Our ref: 25_30828_P

Site Location: Land off Broadgate Weston Hills
Spalding

Summary of Proposal: Rural exception site
of 24 affordable homes

Further to our previous letters dated 25th February 2025 and 14th March 2025, having reviewed the updated documents to support this application, the Board wish to update our comments, shown in bold below.

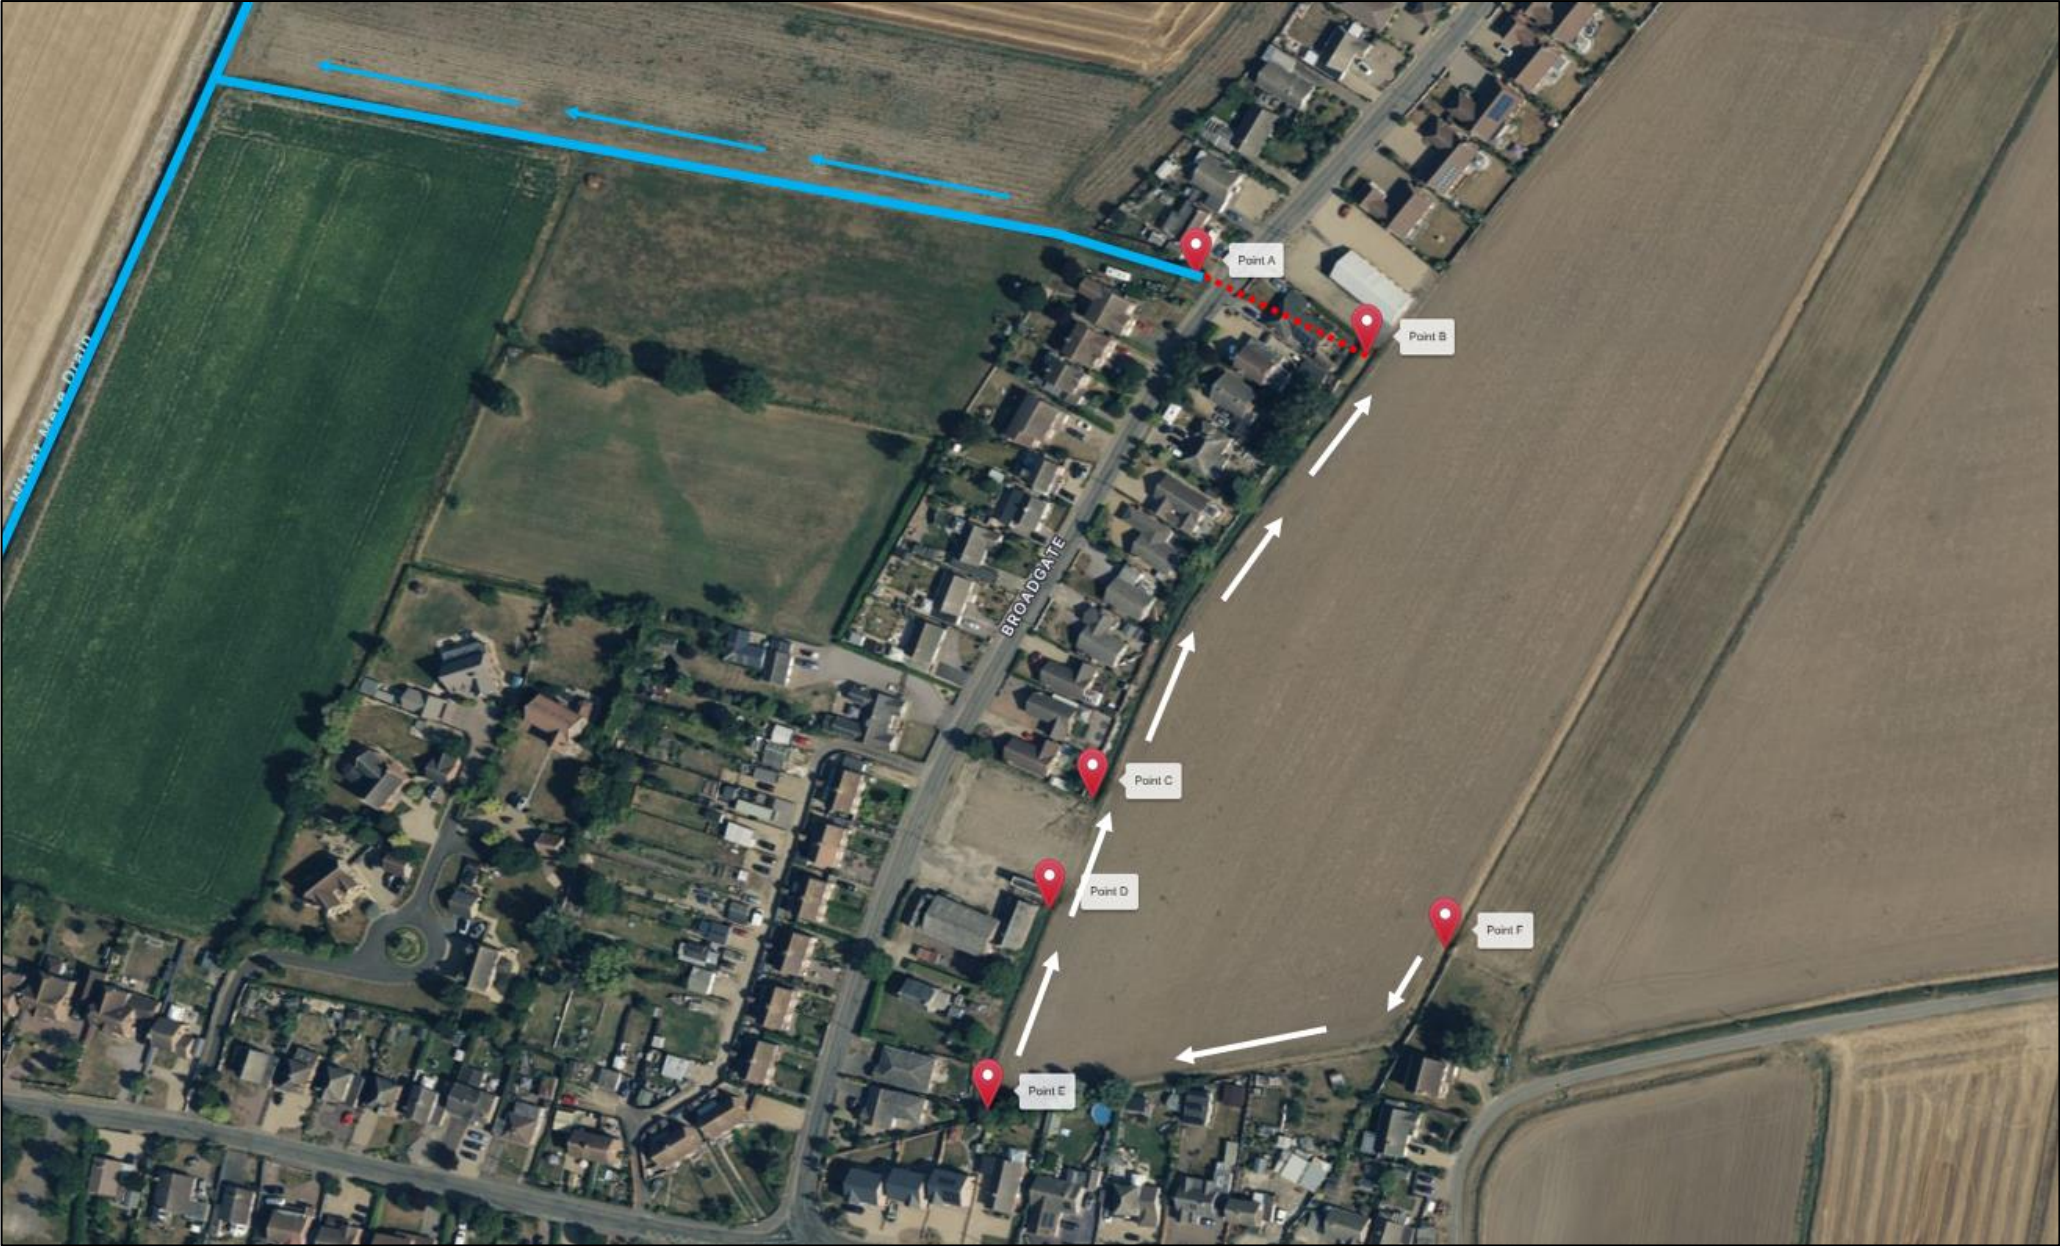
- 2) The Board's watercourse, shown in light blue, begins at point A on the attached plan and flows westwards. A culvert not owned by the Board (shown by the red dashed line), runs under Broadgate Road, enters the riparian watercourse from the west at point B. This culvert connects this riparian watercourse to the Board arterial watercourse. Whilst we are aware of this culvert's

existence, further investigative work is required by the applicant to determine the condition of this culvert to establish whether it is in a suitable condition to accommodate the additional surface water flows from the proposal.

Additionally, the Board are aware of drainage issues at this site, more specifically connectivity issues within the riparian watercourse at points C and D, under the site's proposed access road. The Board do not hold information as to whether there is a pipe connecting these two points. We understand that the applicant is aware of these drainage issues and has subsequently created a temporary route from point E connecting to point C, due to the uncertainty of the existence of a suitable pipe. The Board request that investigative work, including a CCTV survey, is carried out to determine whether there is a pipe connecting the two ends of the watercourse at points C and D and whether it is in a suitable condition to accommodate the additional flows. Succeeding this investigative work, should it be found that this pipe is not in a suitable condition, then an appropriately sized replacement culvert should be installed between points C and D, following an application being made and Consent issued by the Board under Section 23 of Land Drainage Act 1991. The temporary route installed by the applicant can then be removed.

Until a viable discharge route into the Board's system for surface water is proved, **the Board object to this planning proposal** as we are concerned that this application may increase flood risk in the surrounding area due to the lack of a feasible connection from the site to the Board's system. The Board request further investigation and rectification works are carried out to prove that there is a viable connection between the riparian watercourses and the Board's system prior to any application being made to the Board under Byelaw 3 of the Board's Byelaws.

This point has not been addressed and therefore, our objection still stands.

Site Layout 1:500

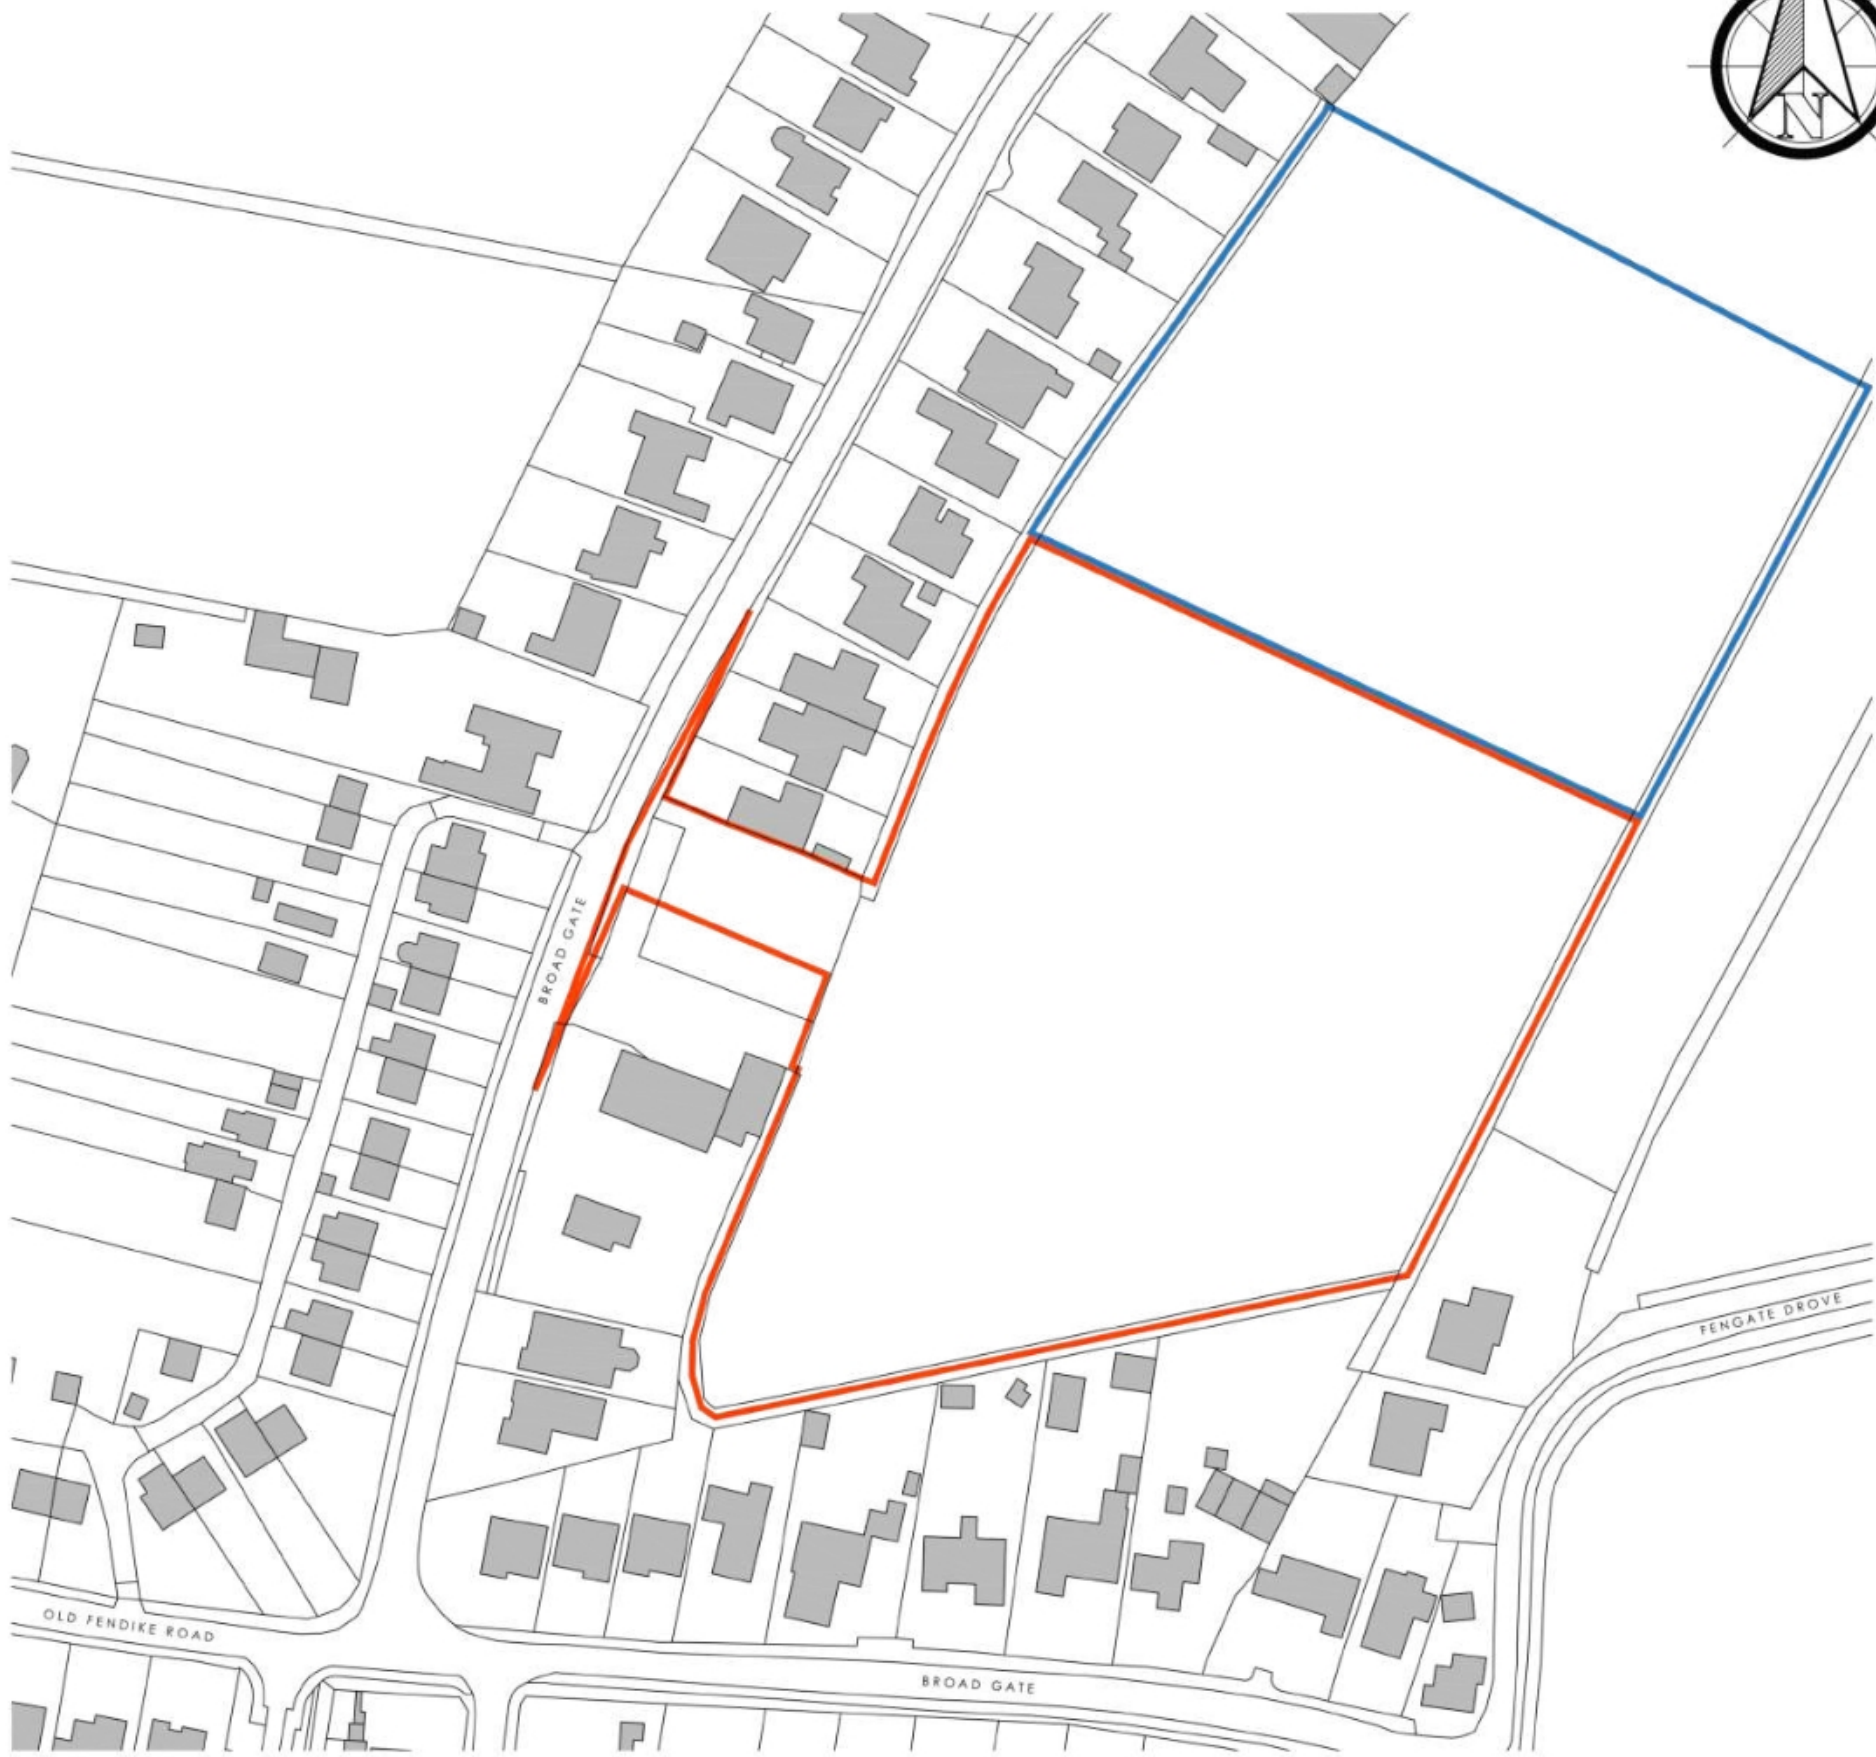
- 3) Lastly, the Board are deeply concerned that no regard to future maintenance of the riparian watercourse has been taken into account when designing the layout for this proposal. The proposed layout does not currently provide a maintenance strip adjacent to the watercourse and will result in the fences of 18 private gardens being installed up to the brink of the watercourse. This will lead to the watercourse having multiple riparian owners under riparian law with no suitable access to carry out their maintenance responsibilities which is likely to lead to flooding issues within the wider site and surrounding area. **The Board therefore object to this planning application** and recommends that the applicant redesigns the layout so that a suitable maintenance strip (around 3-5 metres) is left flat and free from obstruction adjacent to the riparian watercourse in order to enable maintenance by one future riparian owner/designated maintenance company/contractor.

We are pleased to see that the revised "Drainage Strategy" ref: 622-S11-00-SI-SK-C-9000, Rev A, (Studio 11 Architecture, 13.11.25), shows that a management company will be responsible for the maintenance of the riparian watercourse surrounding the site instead of the individual plot owners. However, the layout still suggests that the fences of 18 private gardens will be installed up to the brink of the watercourse. There will be no room for the maintenance company to access the watercourse for maintenance purposes and disposal of arisings, other than walking within the channel. We seek clarity around the proposed maintenance regime of the watercourse and would suggest that once agreed this is made conditional in any planning permission granted. We would expect that the watercourse will need to be regularly cleared of vegetation and periodically desilted – how will this be achieved?

It is still likely therefore that a lack of access for maintenance will lead to flooding issues within the wider site and surrounding area. The Board therefore maintains its objection to this planning application and recommends that the applicant redesigns the layout so that a suitable maintenance strip (around 3-5 metres) is left flat and free from obstruction adjacent to the riparian watercourse in order to enable maintenance by the designated maintenance company/contractor.
